## KITTITAS COUNTY DEPARTMENT OF PUBLIC WORKS

### MEMORANDUM

TO: Community Development Services  
FROM: Taylor Gustafson, Environmental/Transportation Planner  
DATE: March 22, 2019  
SUBJECT: Ranch Road Final Cluster Plat (LPF-19-00002)

**Please find Public Works final review comments below:**

DATE 02/20/19 JOB NO. 07132
DWN BY D.L.P./G.W. CHD BY 1 OF 3
SCALE 1" = 200' SHEET 1 OF 3

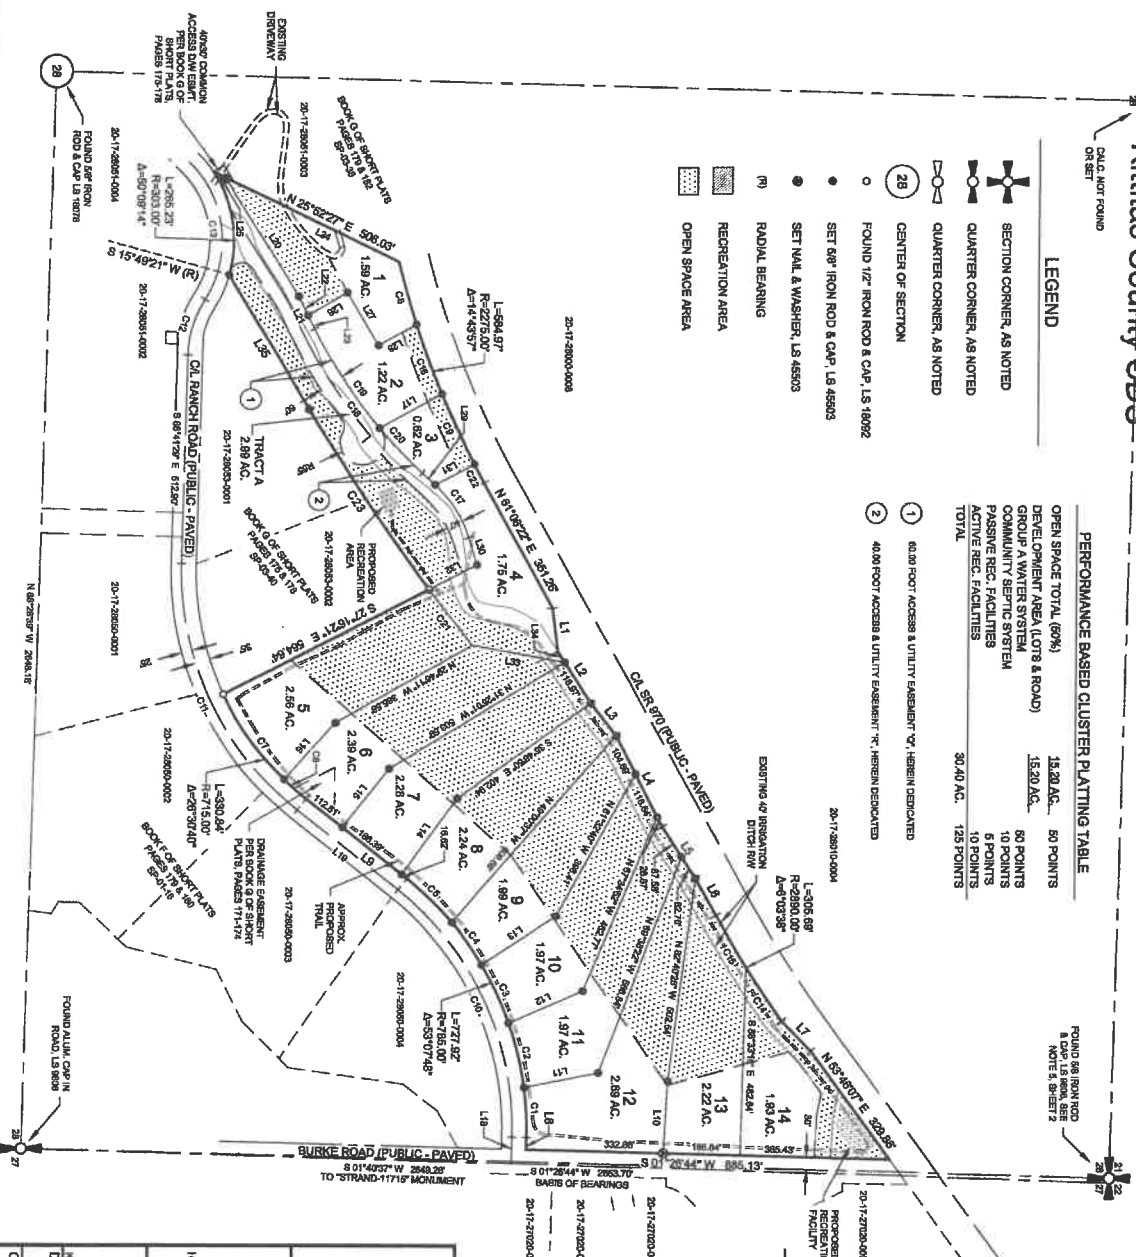
##### Sheet 1

1. The dimensions for the North line of Lot 13, and the Northeast line of Lot 8 are obscured by crossing linework.
2. The division line between lots 13 and 14 should be monumented in the field.
3. The ownership of public right of way should be clarified as being county or state.
  - a. EX: "Burke Rd – County R/W – Paved"
4. The open space limits are not retraceable / locatable.
5. The existing driveway serving lot 1 should include reference to the 20 foot access easement recorded under AFN: 201903130003.
6. The access easement serving lots 2, 3 and 4, should be shown as dedicated right of way OR clear language included on the face of the plat that the entirety of Tract A shall fall under ownership of a homeowners association, so as to protect the county from undesired ownership through absentee land tax.

7. Lot 1: An access easement needs to be shown on the face of the plat for lot 1.
8. Timing of Improvements: This application is subject to the Kittitas County Road Standards, dated 9/6/05. The following conditions apply and must be completed prior to the issuance of a building permit for any of the structures within this plat. A Performance Bond or acceptable financial guarantee may be used, in lieu of the required improvements, per the conditions outlined in the current Kittitas County Road Standards.
9. Private Road Certification: Private roads serving any of the lots within this development shall be inspected and certified by a licensed professional engineer for conformance with current Kittitas County Road Standards, 9/6/05 edition. Kittitas County Public Works
